J.S. THOMPSON
ENGINEERING, INC

April 17, 2024

Re: Americas Best House Plans – Amber

The above noted plan for your residence under construction in Lillington, North Carolina was reviewed to address the lug footing noted by the inspector.

**S-1**  
BASEMENT  
FOUNDATION PLAN

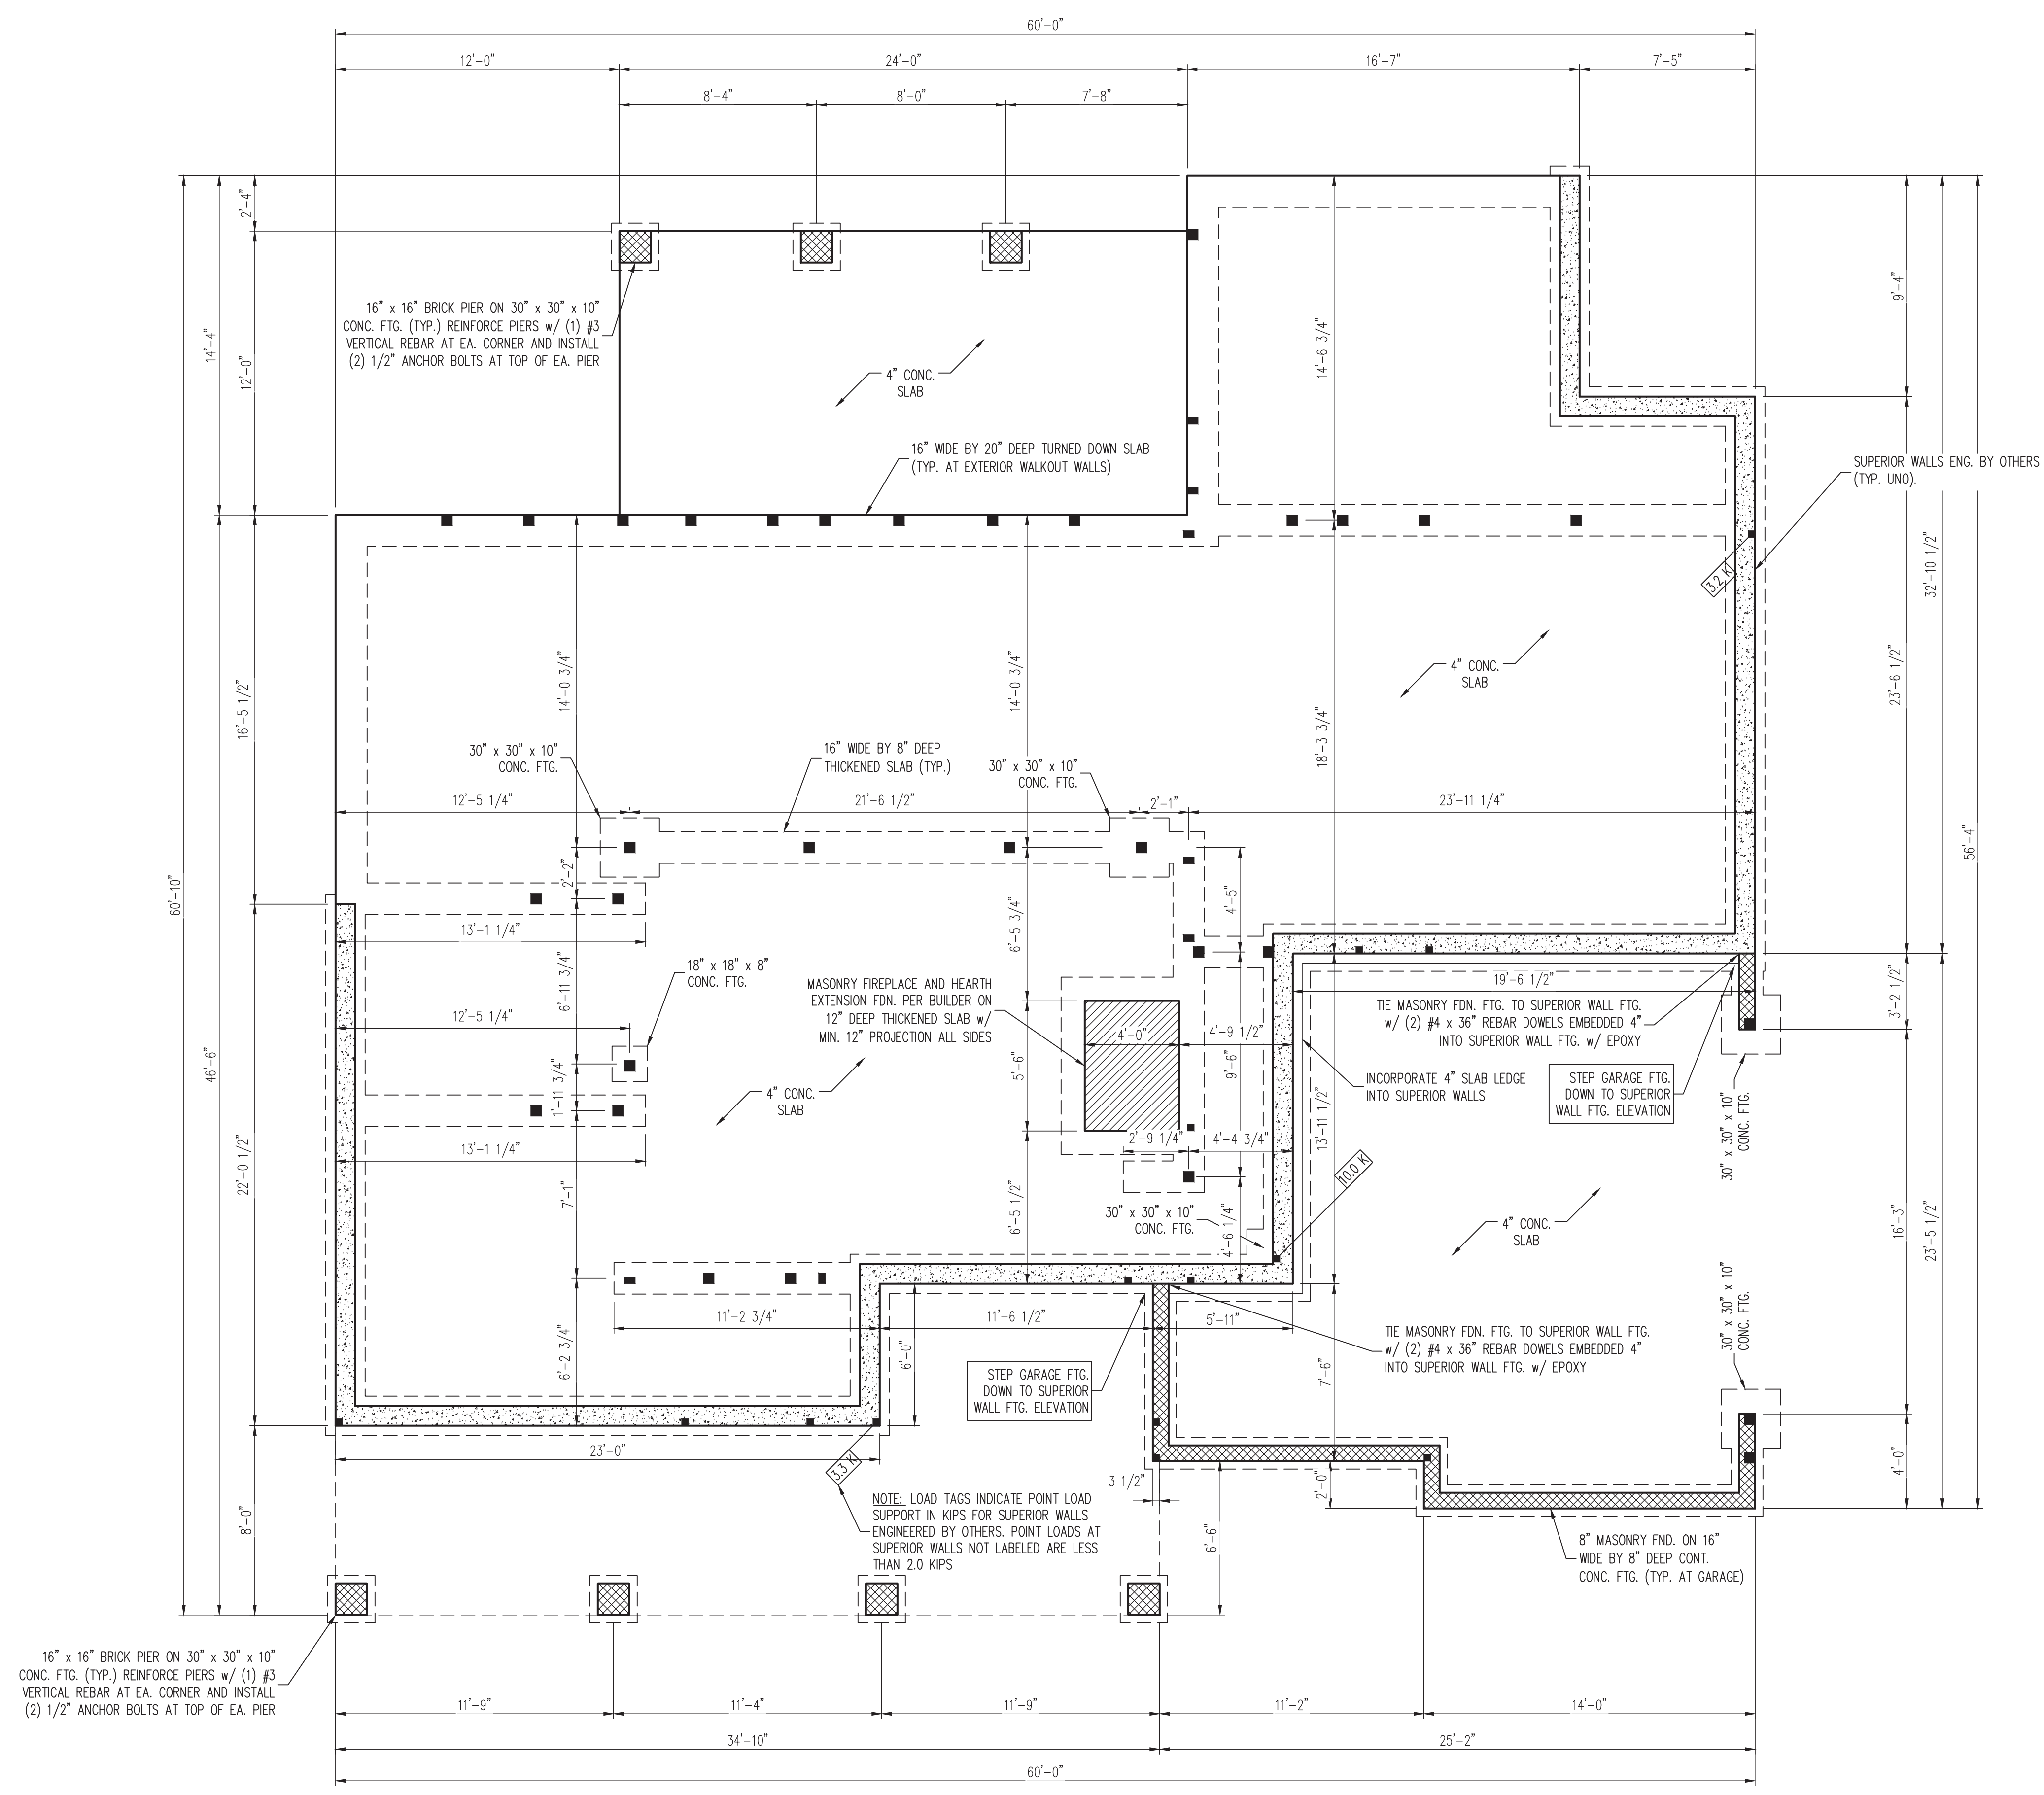
The short section of lug footing extending front to back from the left rear corner of the stairs to the end of the lug footing running left to right is not required with an omitted masonry fireplace. Framing was modified to eliminate loads on the wall from above. This configuration will provide the required support for all applied loads.
